DRB Application No.: <u>06DRB-00918 (P&F)</u>	Project # <u>1004120</u>
Project Name: <u>ALVARADO GARDENS UNIT 3</u>	
Agent: <u>Surveys Southwest</u>	Phone No.: <u>998-0303</u>

SURVEYS SOUTHWEST LTD agent(s) for ROBERT RUTH request(s) the above action(s) for Lot(s) 30-A, 30-B-2-A & 30-B-2-B, **ALVARADO GARDENS, UNIT 3**, zoned R-2 residential zone, located on CANDELARIA RD NW, between GLENWOOD NW and VERANDA RD NW containing approximately 2 acre(s). [REF: 05DRB-00622] (G-12) **THE PRELIMINARY AND FINAL PLAT WAS APPROVED WITH FINAL PLAT SIGN OFF DELEGATED TO TRANSPORTATION DEVELOPMENT TO CHECK FOR 6-FOOT SIDEWALKS.**

DRB CASE NO/PROJECT NO: 1004120

ALVARADO GARDENS
 UNIT 3
 SEC 1, T. 10 N., R3E
 ALBUQUERQUE, BERNALILLO COUNTY, NEW MEXICO
 MARCH 2005

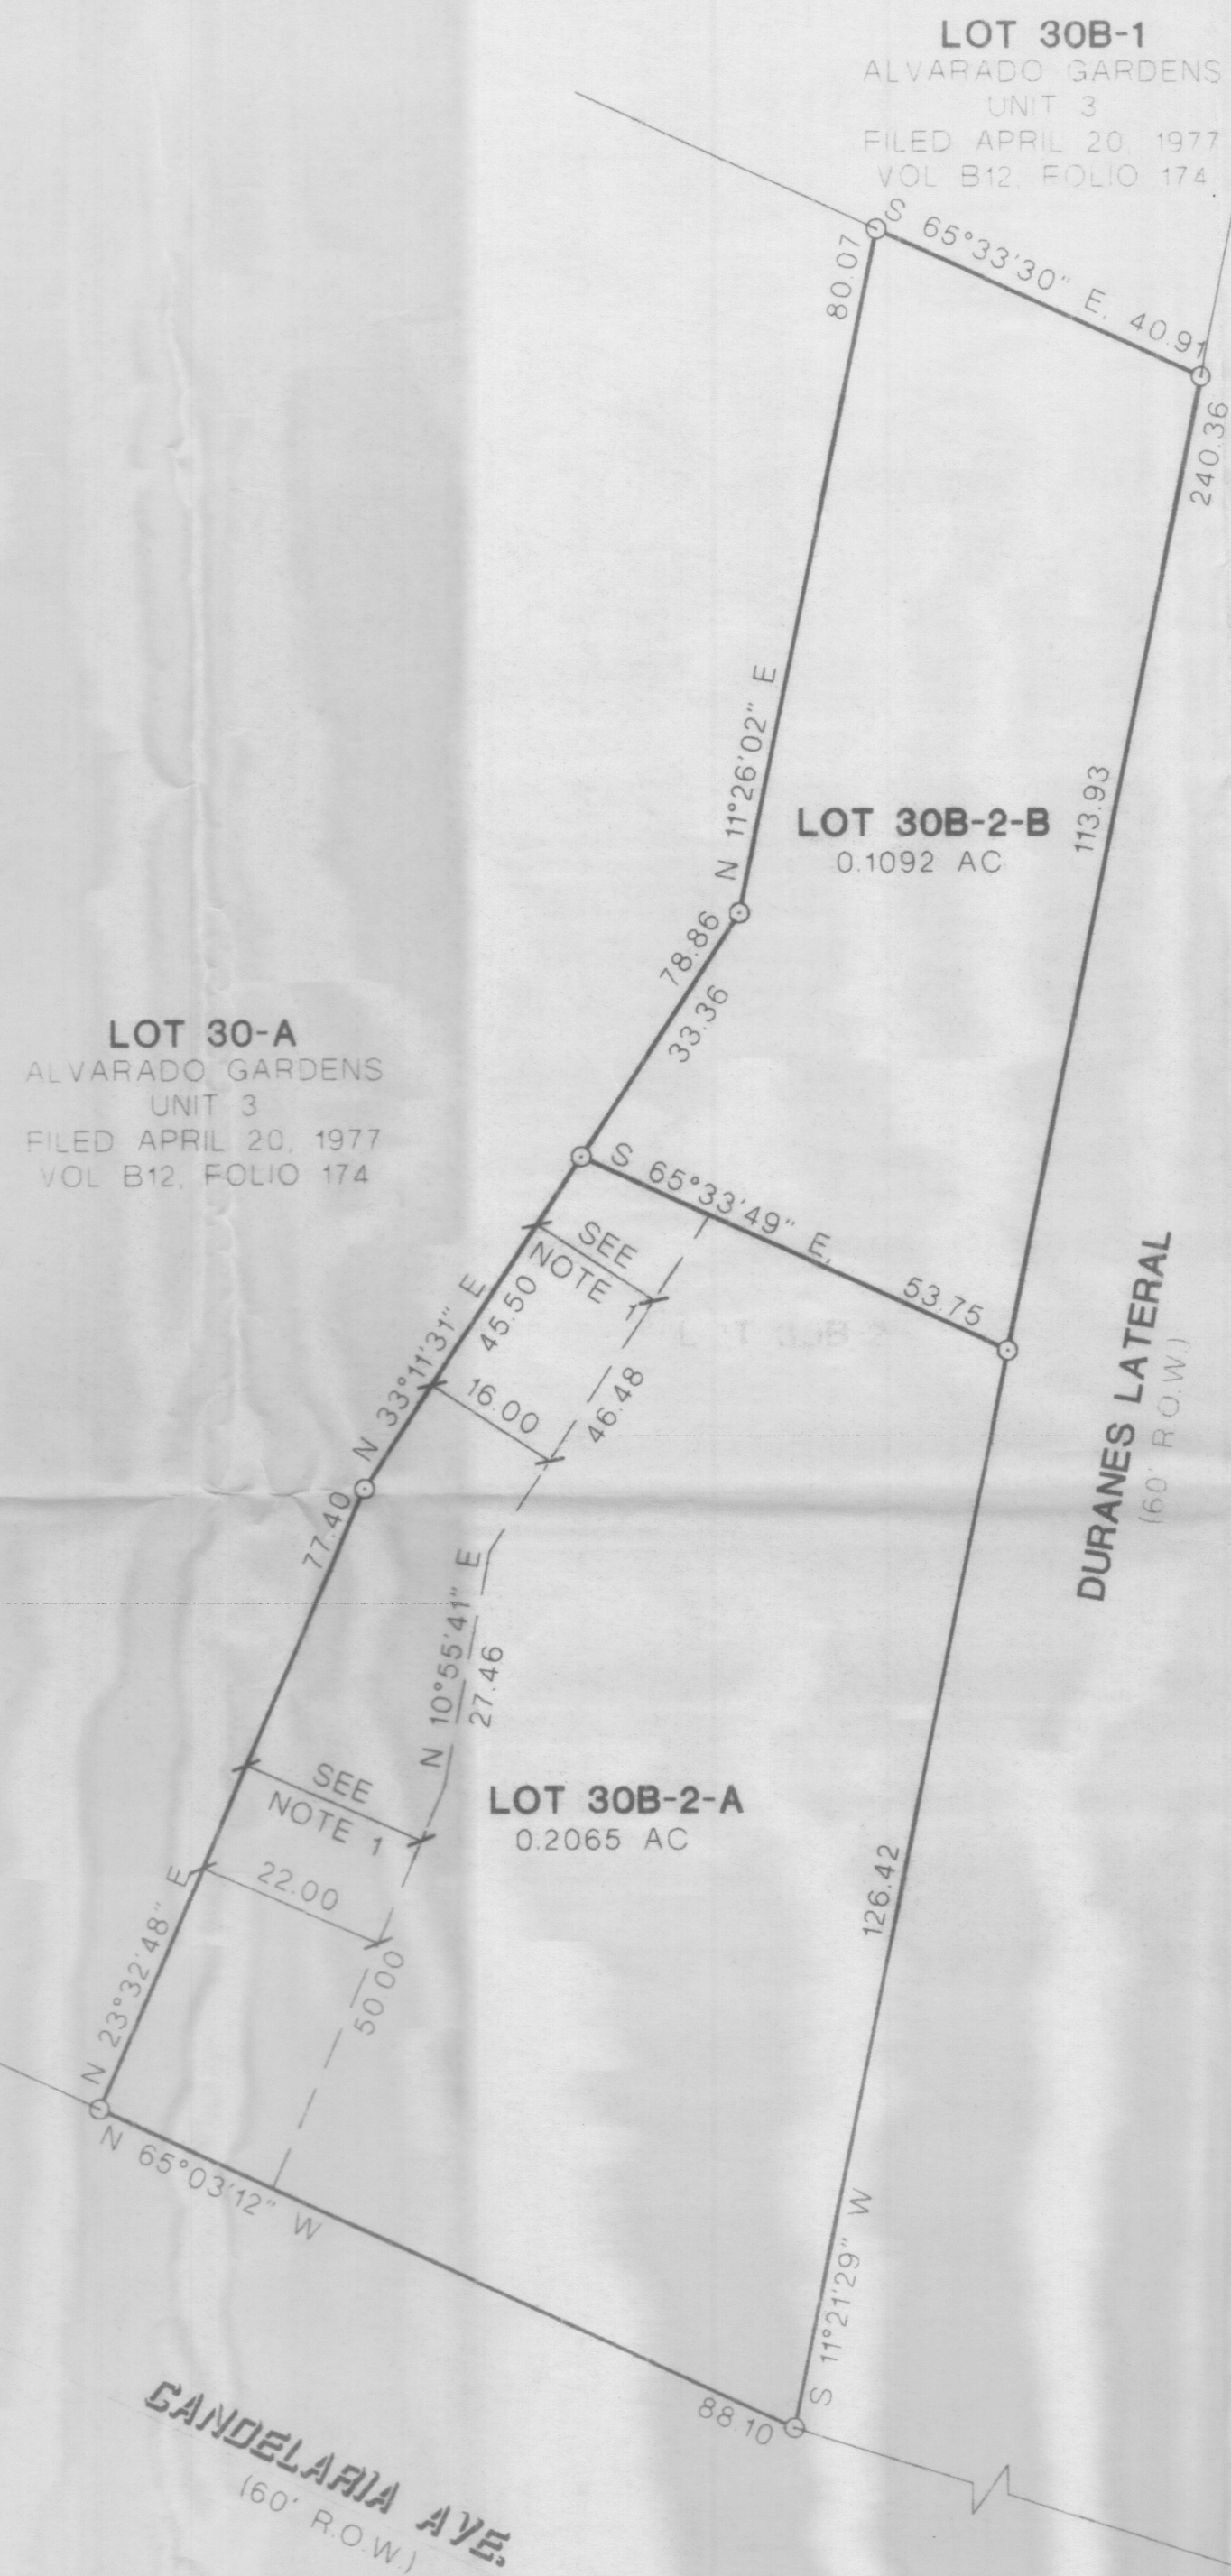
Maintenance and beneficiaries of easement must be stated on plat.
